**RE: Shawn McWethy Park  
Grading and Drainage Plan  
Grading Permit / Paving Permit  
Engineer's Stamp Date 12-22-2015 (File: J09D023A)**

Based upon the information provided in your submittal received 12-22-2015, the above referenced Grading and Drainage Plan is approved for Grading Permit and Paving Permit.

**RE: Shawn McWethy Park  
Grading and Drainage Plan  
Grading Permit / Paving Permit  
Engineer's Stamp Date 10/19/2015 (File: J09D023A)**

Based upon the information provided in your submittal received 9-15-2015, the above referenced Grading and Drainage Plan for Grading Permit and Paving Permit cannot be approved until the following items are addressed in a revised submittal:

1 SWALE SECTION A-A CAPACITY

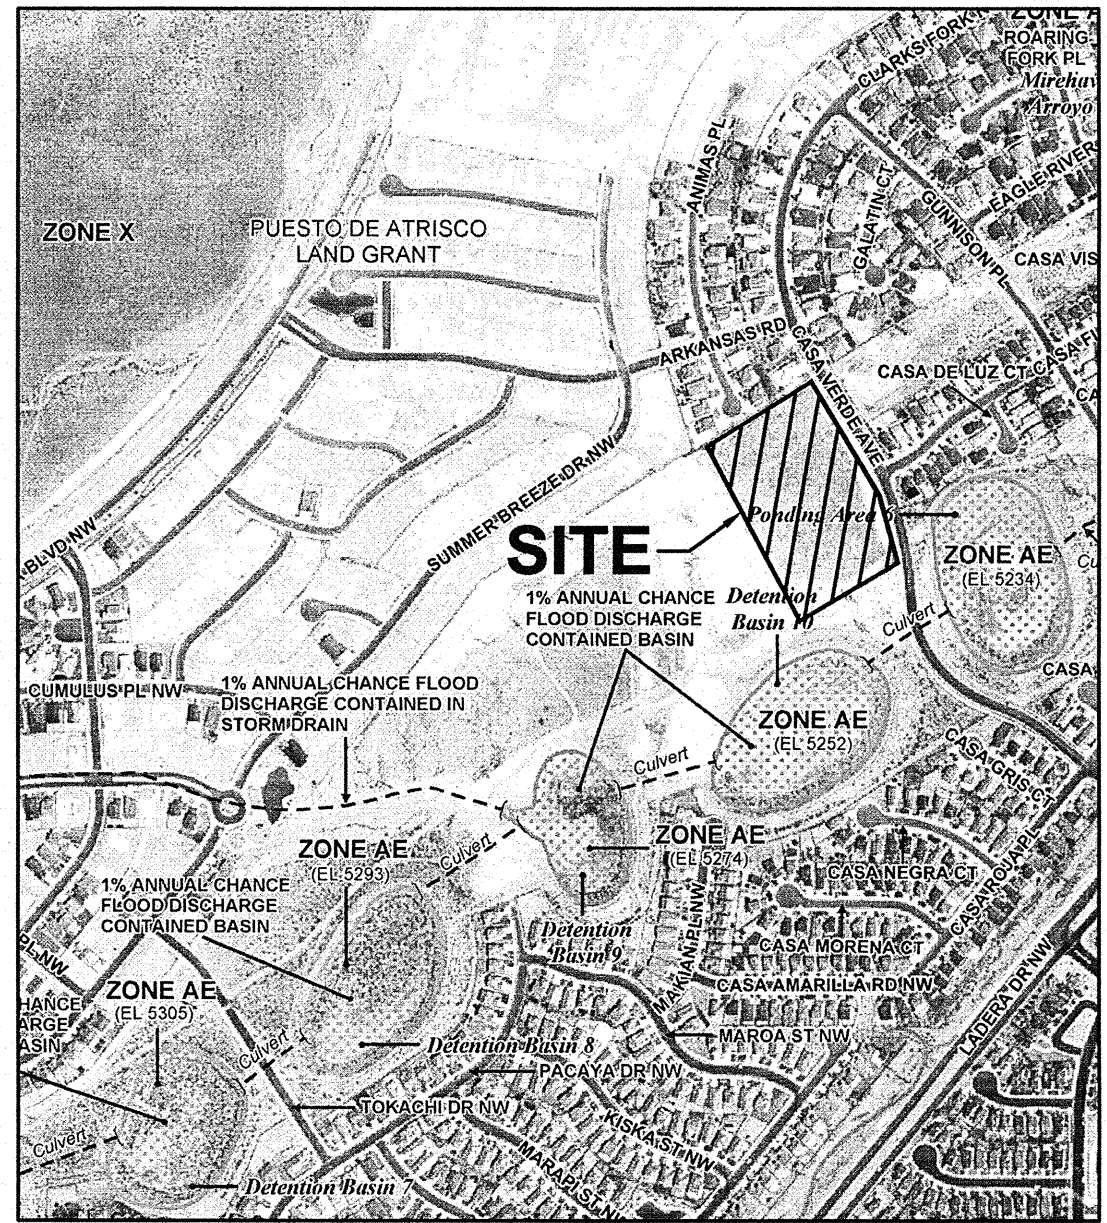
- Provide an excerpt from the approved Drainage Masterplan referenced (cover, table of contents and applicable section), which allows the peak discharge of 15.07 cfs from the site.
- Provide a capacity calculation for the swale along the north edge of the property.
- Provide a capacity calculation for the rundown from Basin 7.
- Clarify how the first flush from the parking lot enters the water quality pond.
